East Anglia One North (EA1N) and East Anglia Two (EA2) Offshore Wind Farms

Planning Inspectorate Reference: EA1N – EN010077, EA2 – EN010078

Deadline 1 - 2 November 2020

East Suffolk Council's and Suffolk County Council's Response to Examining Authority's
First Round of Written Questions

| <br><b>SCOTTISHPOWER</b><br><b>RENEWABLES</b> |            |             |           |                |                  | 1:7,000  |  | <h1>East Anglia ONE North</h1> <h2>Bat Roost and Commuting/Foraging Habitat Results</h2> | <b>Drg No</b> | EA1N-DEV-DRG-IBR-000936 |   |

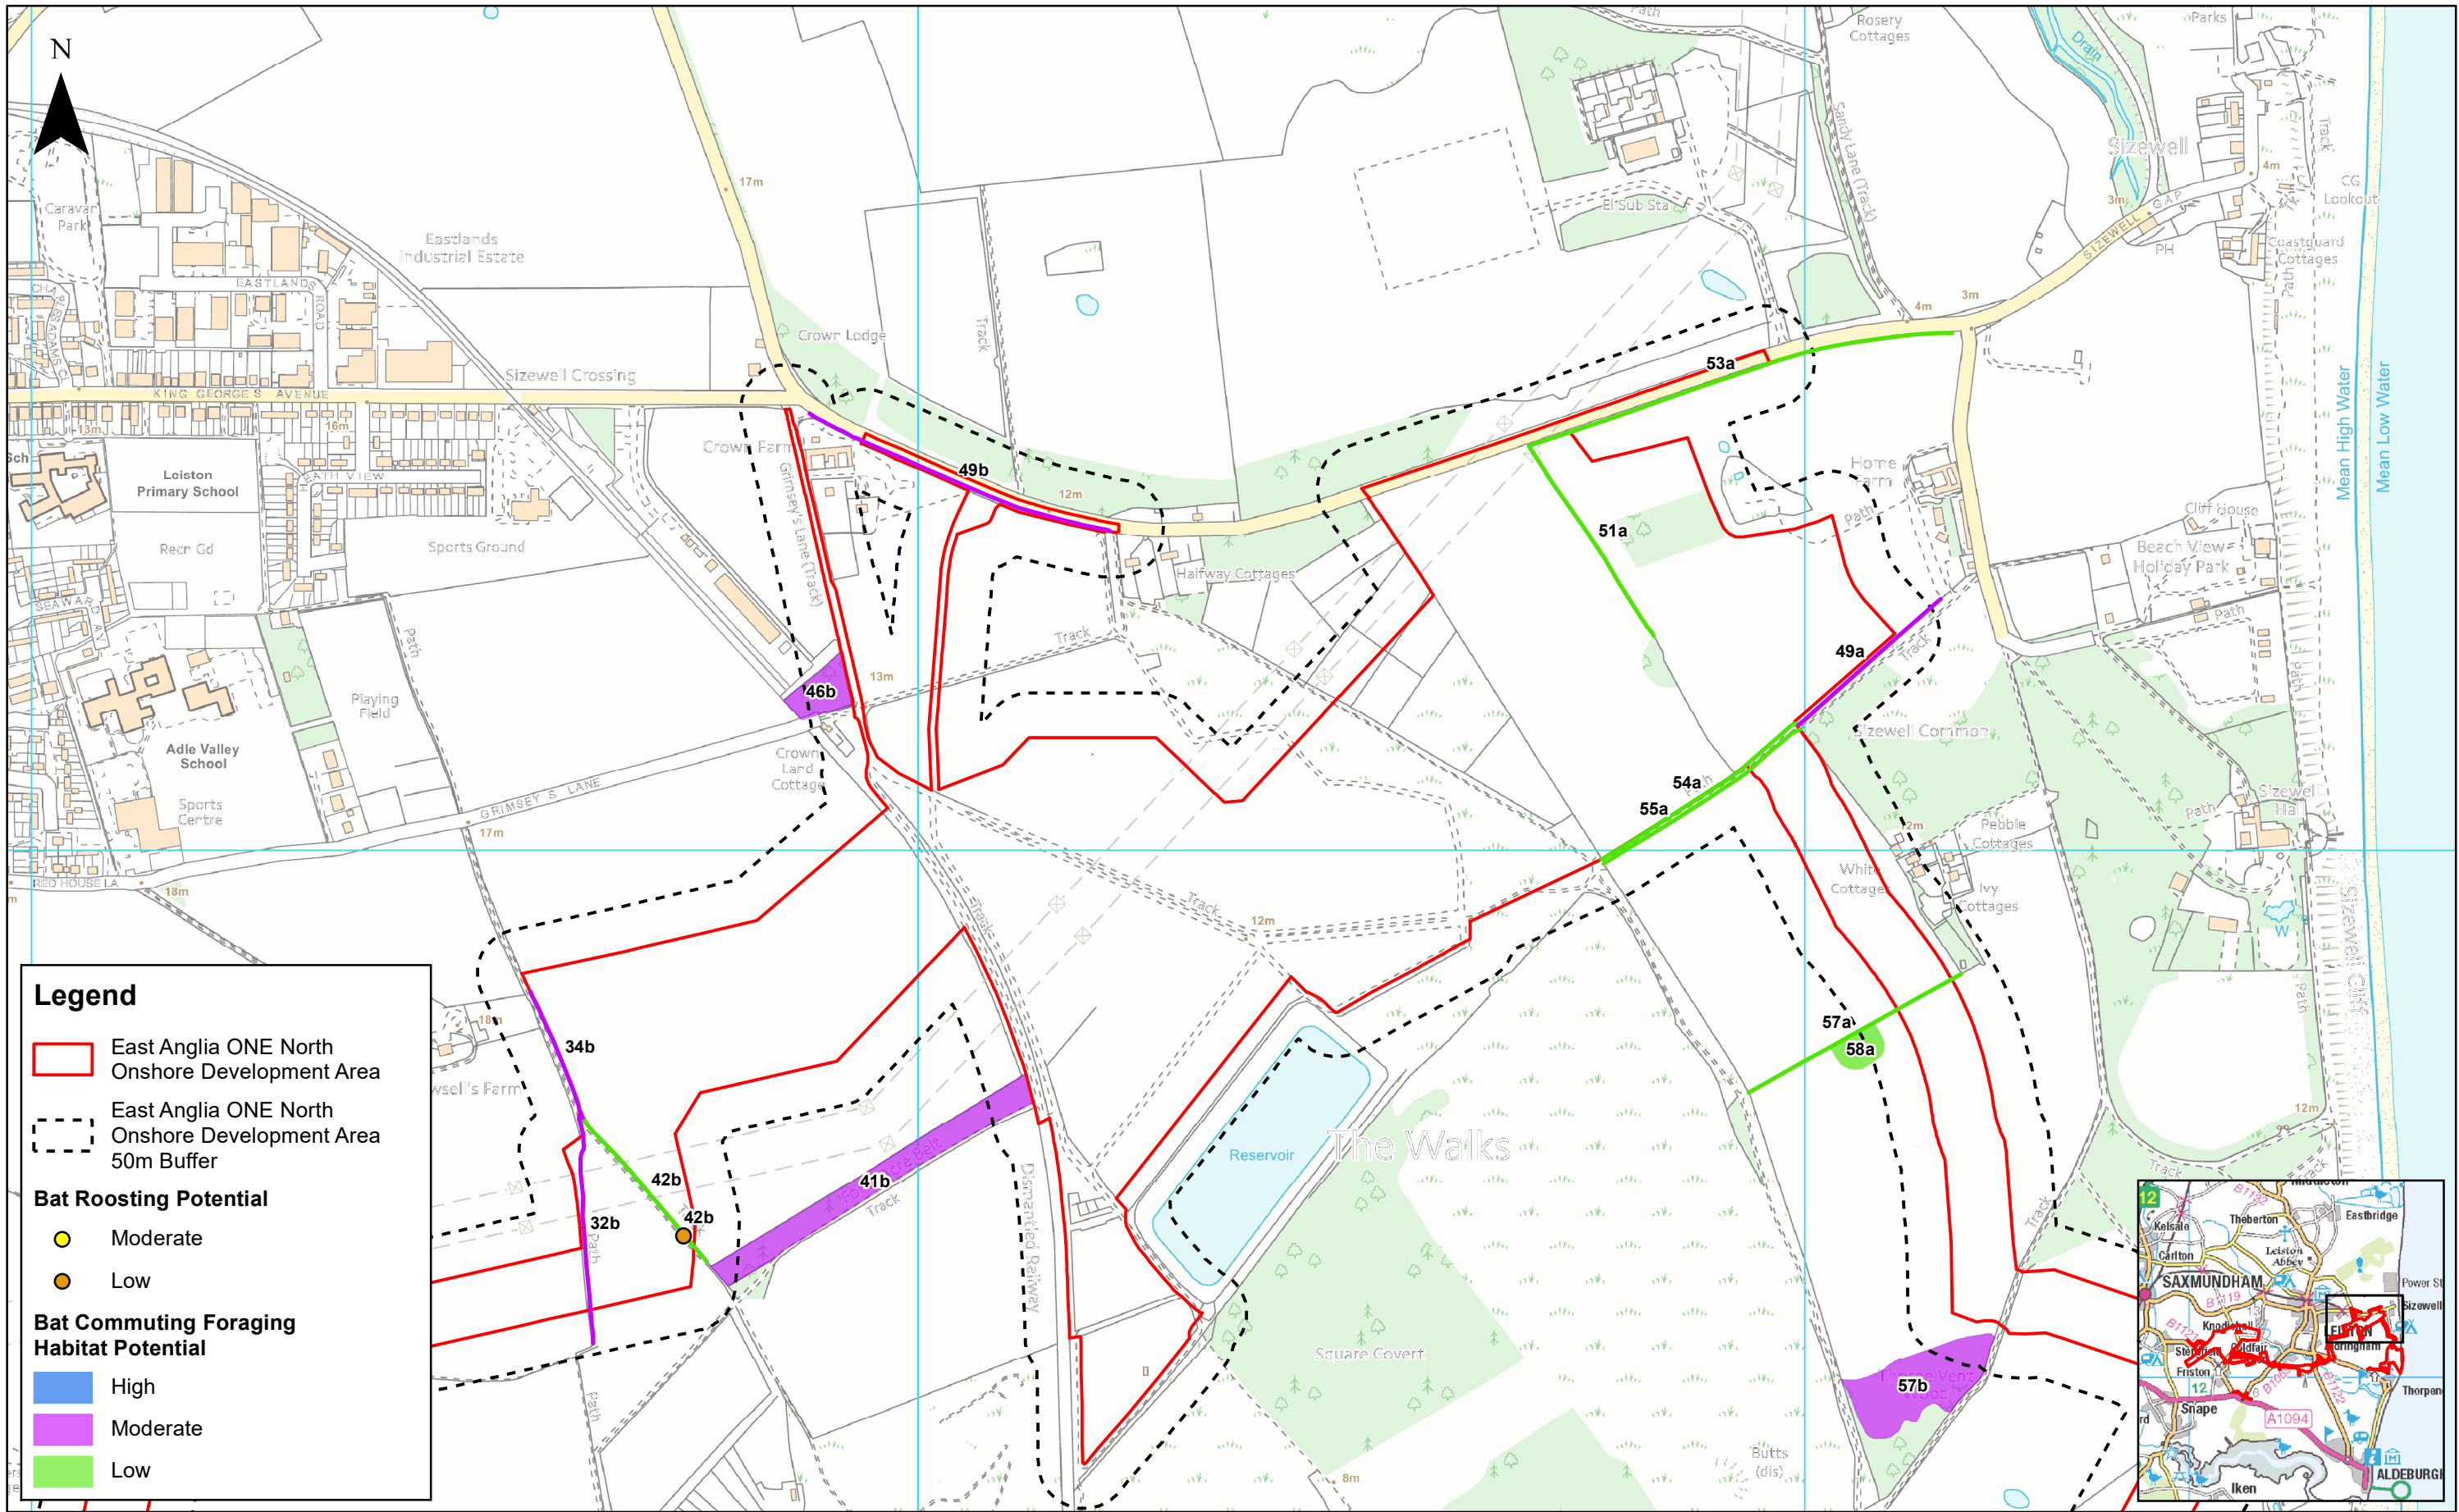
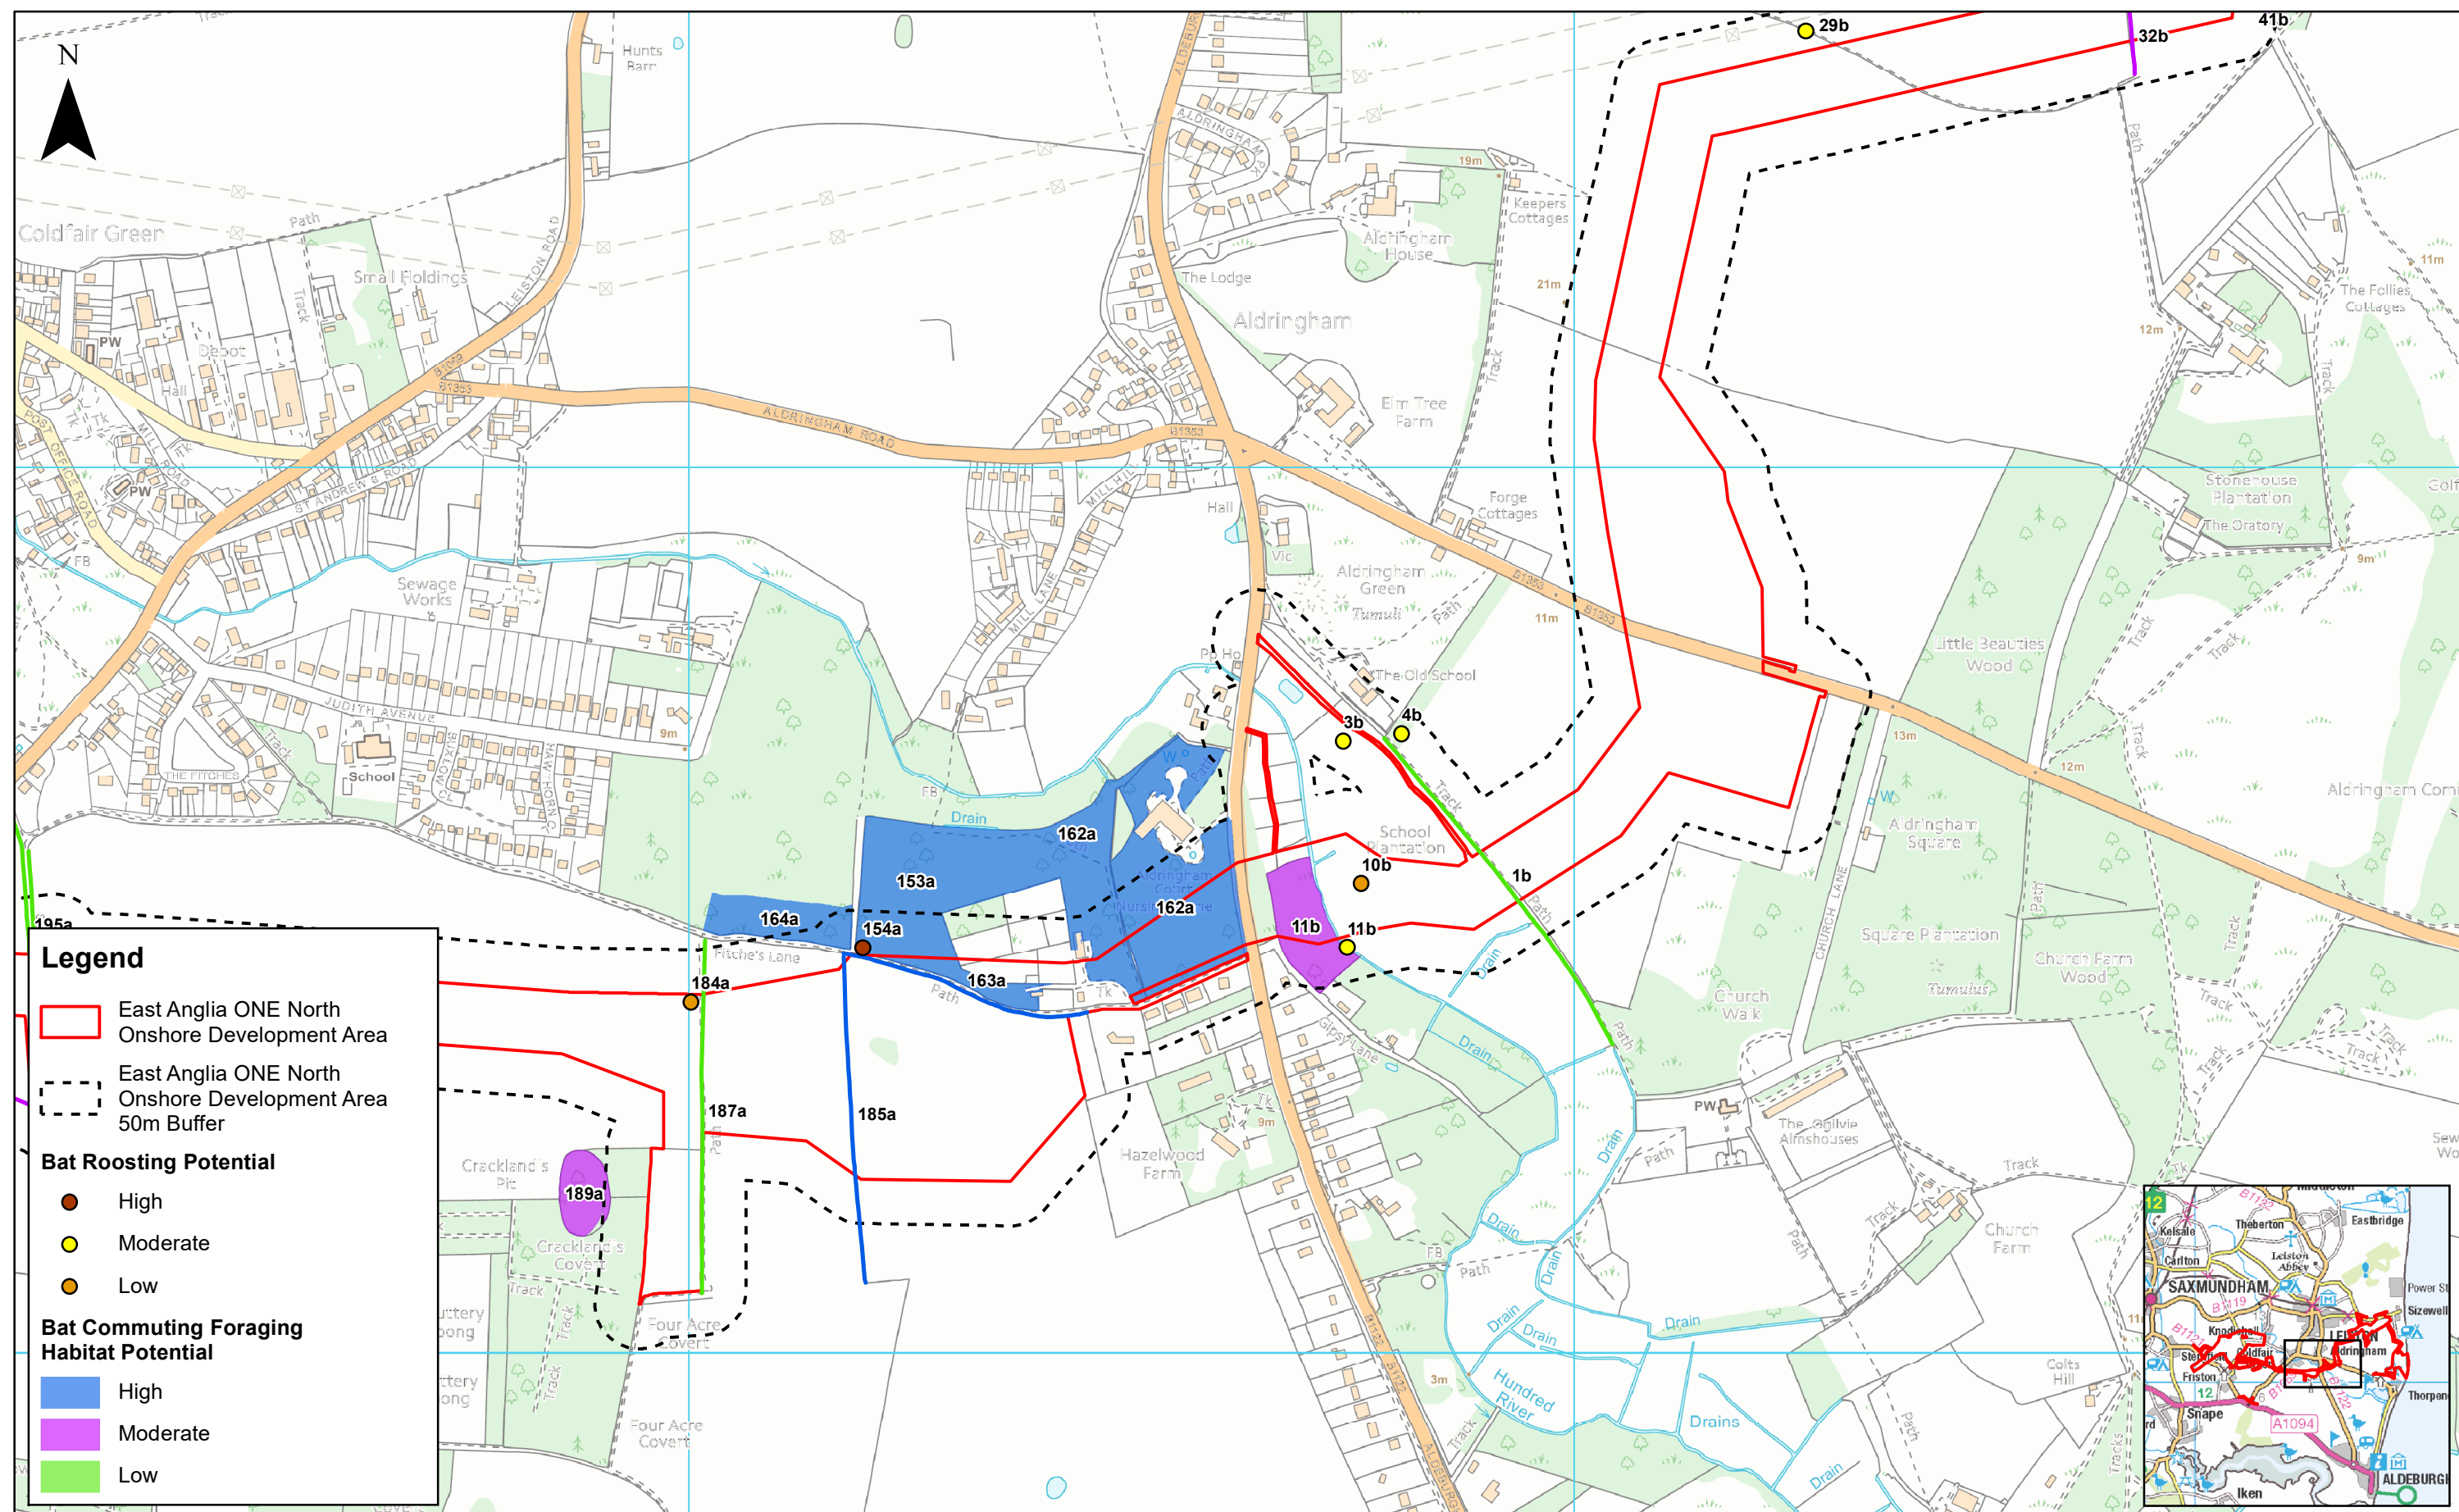
<p>transects were chosen? Why was long covert excluded from transect 2 [APP-281]?</p> <p>f) Could the Applicant confirm if they intend to submit an outline hedgerow mitigation plan?</p> <p>g) Are Natural England/ESC/SCC/Suffolk Wildlife Trust satisfied that the reinstatement, management and maintenance of the replacement hedgerows is satisfactorily secured? Should this be contained within the LMP or EMP?</p> <p>h) Can the Applicant please confirm when an updated CIA with Sizewell in relation to bats will be submitted into the Examination?</p> <p>Please can Natural England confirm that they are satisfied that Figure 22.7a-g [APP-280] clearly maps the roosting, foraging and commuting areas for bats in relation to the red line boundary?</p>
